CITY OF ALBUQUERQUE

PLANNING DEPARTMENT – Development & Building Services

September 19, 2012

Re: Francisco Lopez, Bridge/Eucariz Grading & Drainage Plan (L-11/D067)
Lot 316A, Unit 3, Town of Atrisco Grant Engineer's Stamp dated 08-15-12

## GRADING & DRAINAGE PLAN

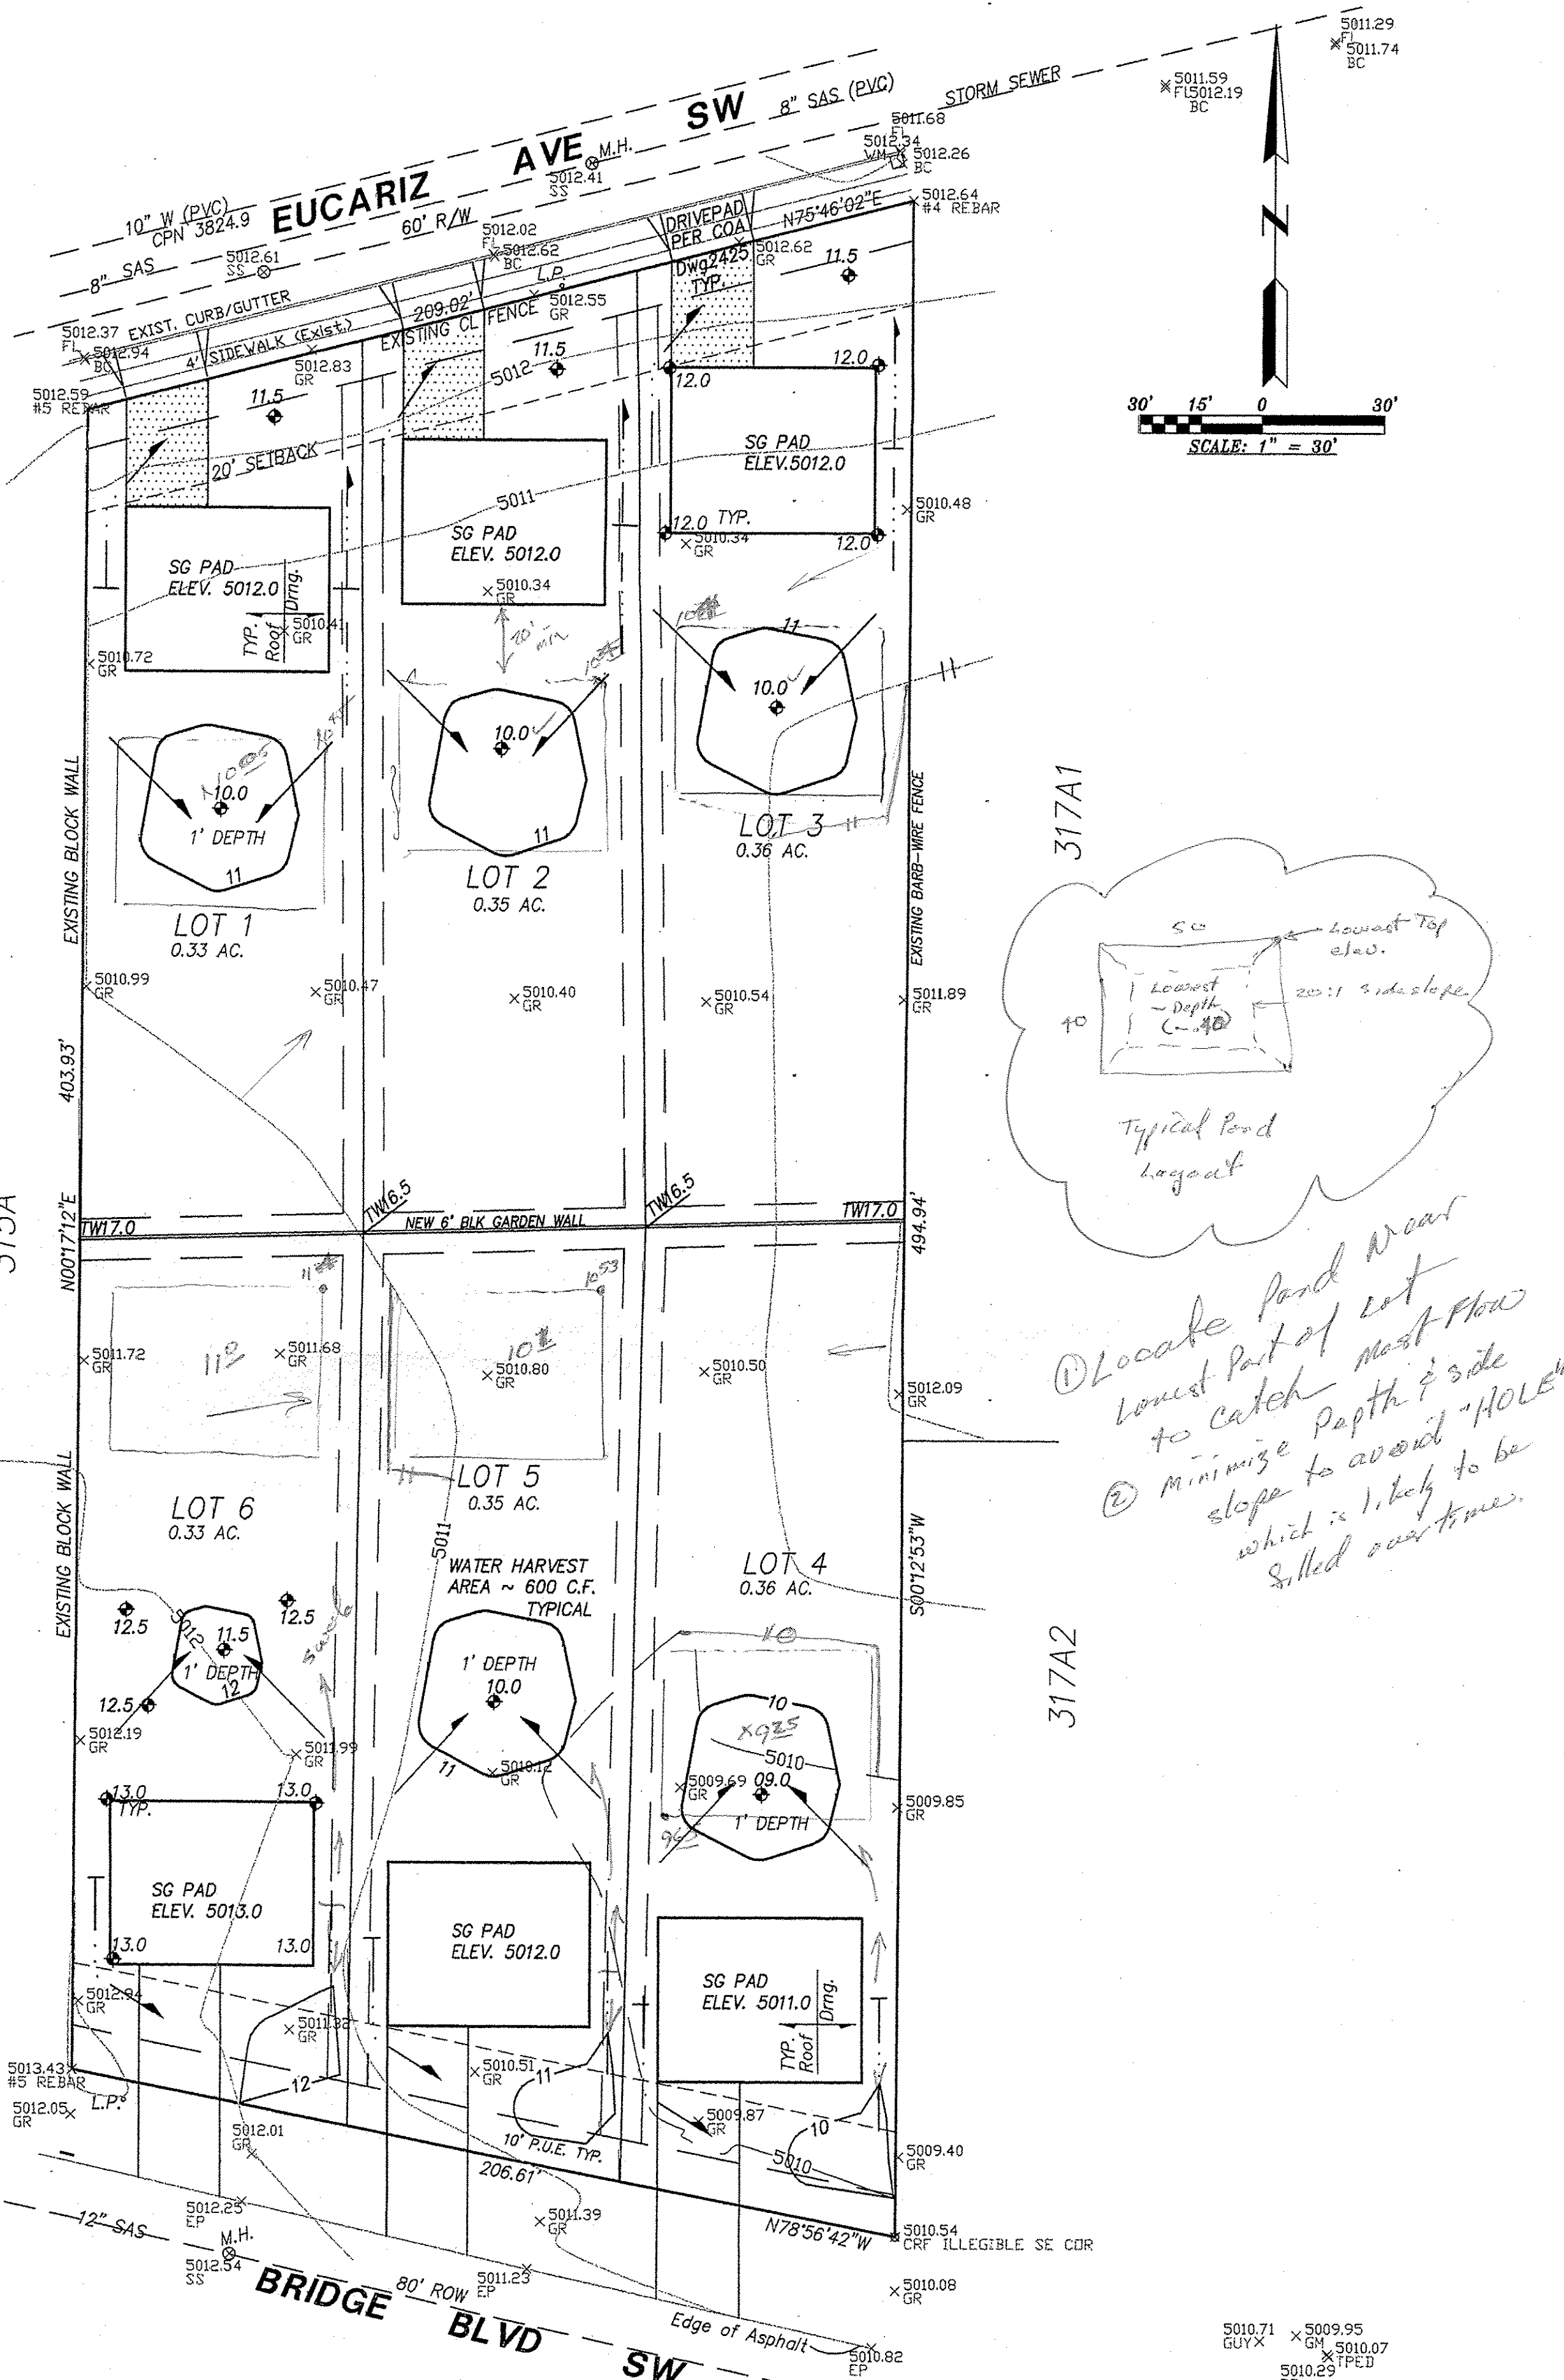
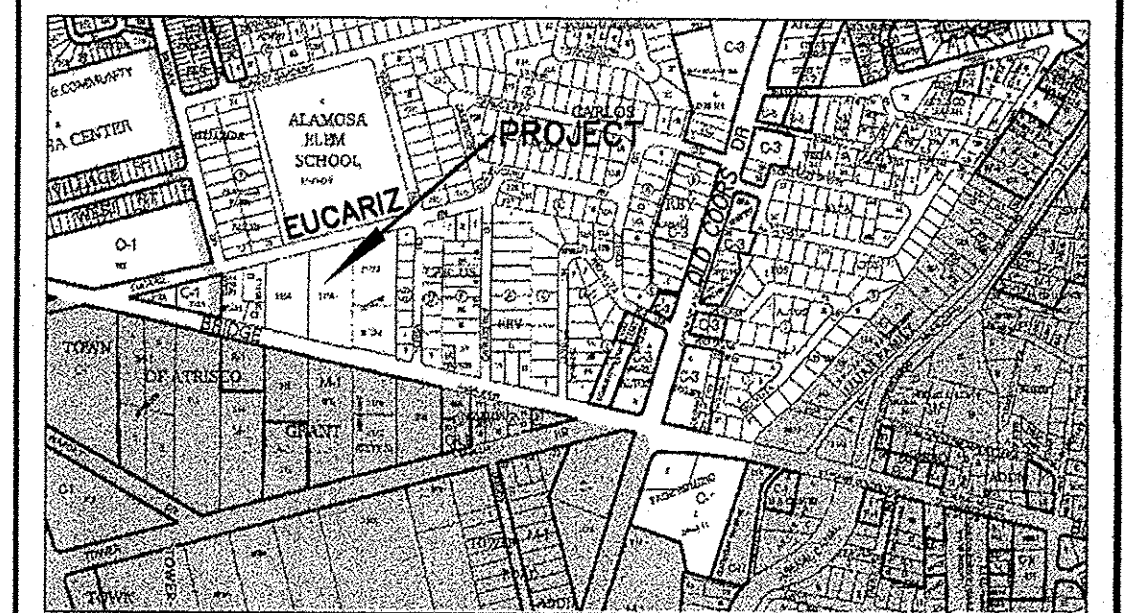
1. Discharge from this site is only allowed to be “FREE” if discharging to the street. Cross lot runoff must be limited to historic rates.
2. Run off and pond volume calculations must be included on the plan or in an accompanying table or report. Clearly label values used or estimated.

3. The small, 1’ deep, backyard ponds are not acceptable, as they tend to get filled in over time, after the properties are occupied. Larger, shallower ponding areas should be shown, and located at the lowest area of each lot to allow all runoff to reach the pond. The whole-foot contours shown for the proposed ponds do not clearly show the pond size/limits of grading. Show a “water surface contour” to clarify the pond limits on your plan.

4. The front yard ponds along Eucariz need to be clarified, showing limits with “water surface contour” and overflow course.
5. The driveways from the northern lots to Eucariz are shown to drain to the NE, however spot elevations at R/W and on the pad indicate slope back toward the building pad. Clarify with spot elevations and swale arrows how this flow is routed.

6. Provide spot elevations and flow arrows on proposed swales indicating the direction of all flows to ponds and exiting the site.
7. Provide spot elevations around the four corners of the house pads on all lots to clarify drainage. Show how revised grades on this site match existing grades at the eastern property line, and where flows cross that boundary.
